Temperature Controlled Warehouse Facility Modification 2

State Significant Development Modification Assessment
(SSD-8586218-Mod-2)

April 2021

Figure 1 Site Plan

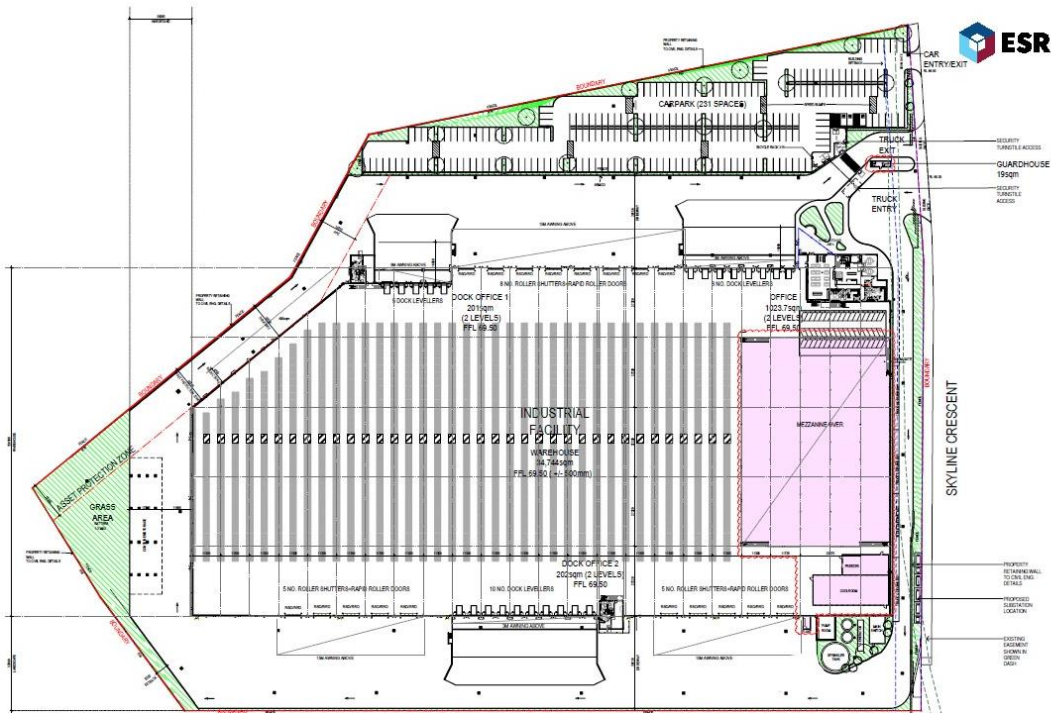
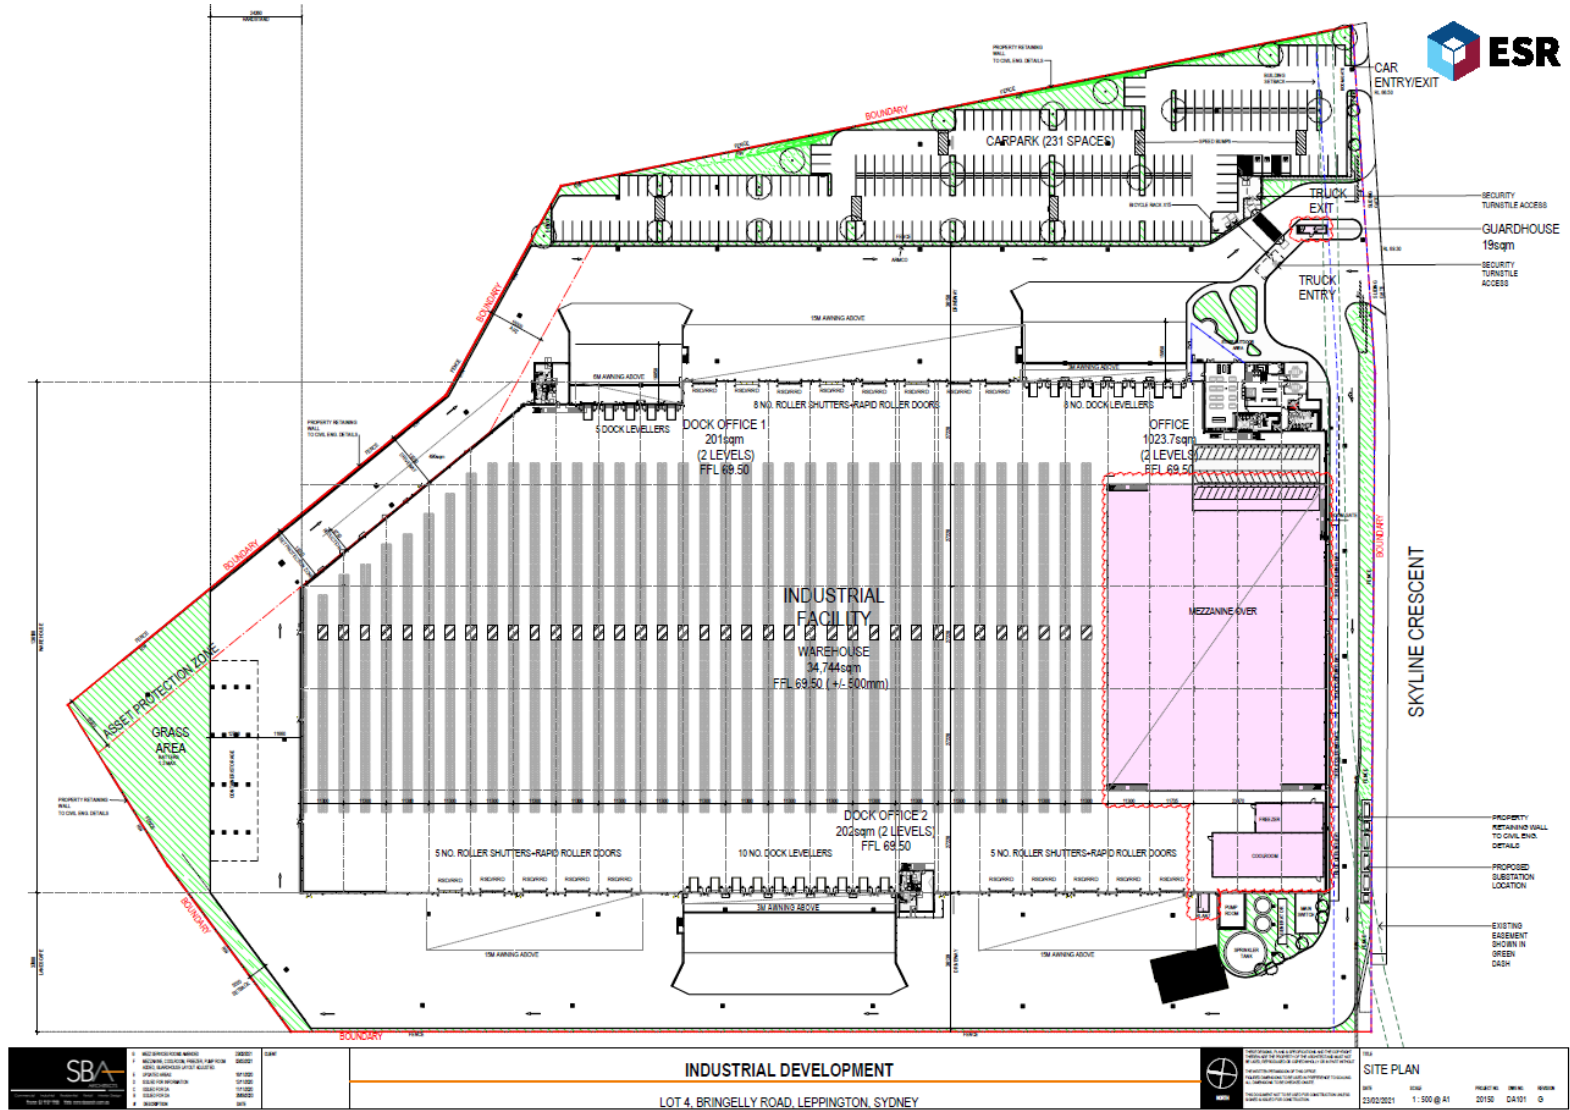
The plan in question is drawing DA101 revision F, approved as part of Modification 1. In response to a Request for Information issued by the Department, the Applicant supplied amended architectural plans on 25 February 2021. These plans addressed issues raised by the Department in response to the mezzanine level, however unintentionally reduced the size of the cold and freezer rooms on the Site Plan only.

The modification application seeks to amend an error on the plans submitted as part of the Department's Request for Information (RFI) in Modification 1. The RFI response submitted updated plans in relation to questions by the Department around the use of the site, however inadvertently submitted a previous version of the Site Plan. This Site Plan was later approved by the Department as part of the approved drawing set. The consequence of approving this Site Plan saw the cold and freezer storage rooms reduced in size, conflicting with that originally provided in the Modification 1 application.

The Applicant is therefore seeking to amend the approved drawings listed on the consent to replace the approved Site Plan with that originally submitted under Modification 1. This will result in the size of the cold and freezer rooms aligning with the size originally proposed.

The Applicant lodged the current modification application to rectify this error, reverting the cold and freezer rooms to the larger dimensions that were originally lodged and considered under Modification 1. It is noted the amended plans were used when consulting with Liverpool City Council in Modification 1.

The Department has reviewed the modification application and considers the Site Plan to have been included in the consent by error. The Department recommends updating the plans listed in the consent to reflect the supplied Site Plan under this modification application. Minor changes to include a new definition of this modification are also recommended, to facilitate the correction of the error.
